Upper Lachlan Shire Council

30 September 2025

Preliminary Submission on DA1-01-2000-Mod-3 Barina Quarry 2692 Collector Road NSW 2581

Figure 1-3: Proposed Modified Quarry Layout

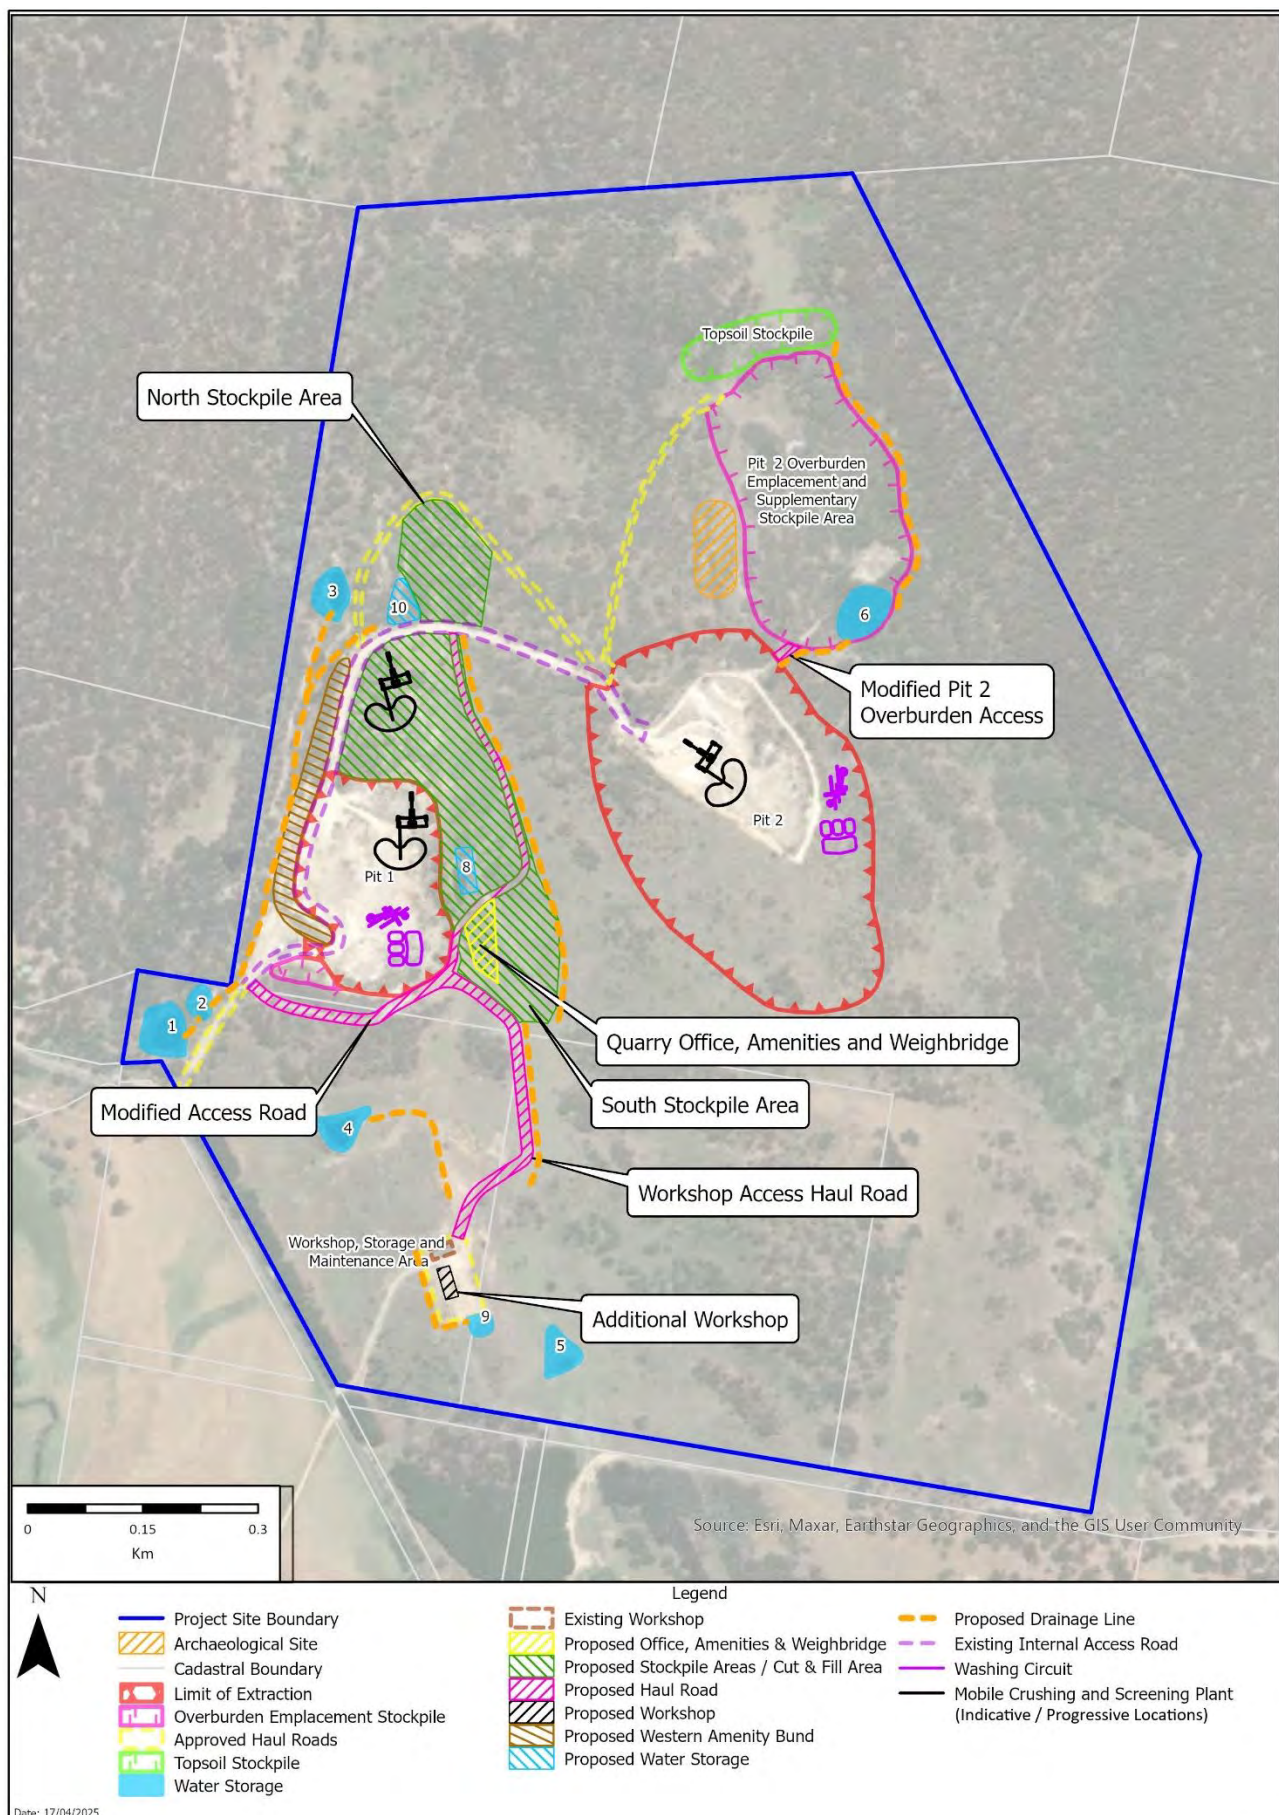
It is not clear in the Modification Report what the total disturbance area will be. There is conflicting disturbance areas observed on page 15, noted as a "minor" increase on page 36 and quantified in terms of additional disturbance on page 45. Additional detail is required to determine the actual change to disturbed area. In addition, as the proposed truck movements and extraction rates are not

intended to increase under the modification, additional information is required to clarify the need for increasing the disturbed area to the extent proposed.

Figure 14: Austroads Guide to Road Design Part 4: Intersections and Crossings: General Figure 7.4

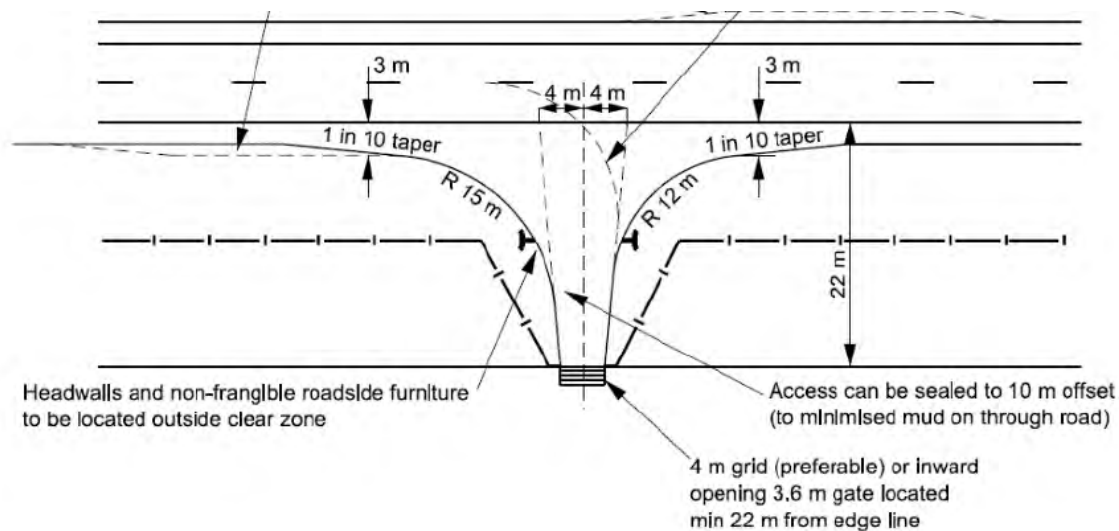
The Modification Report states that there are to be no changes to the existing site access, However, Figure 14 of Austroads Guide to Road Design Part 4: Intersection and Crossings, requires the access to be upgraded to a bitumen seal. Council officers recommend that this requirement be included as a condition of consent.
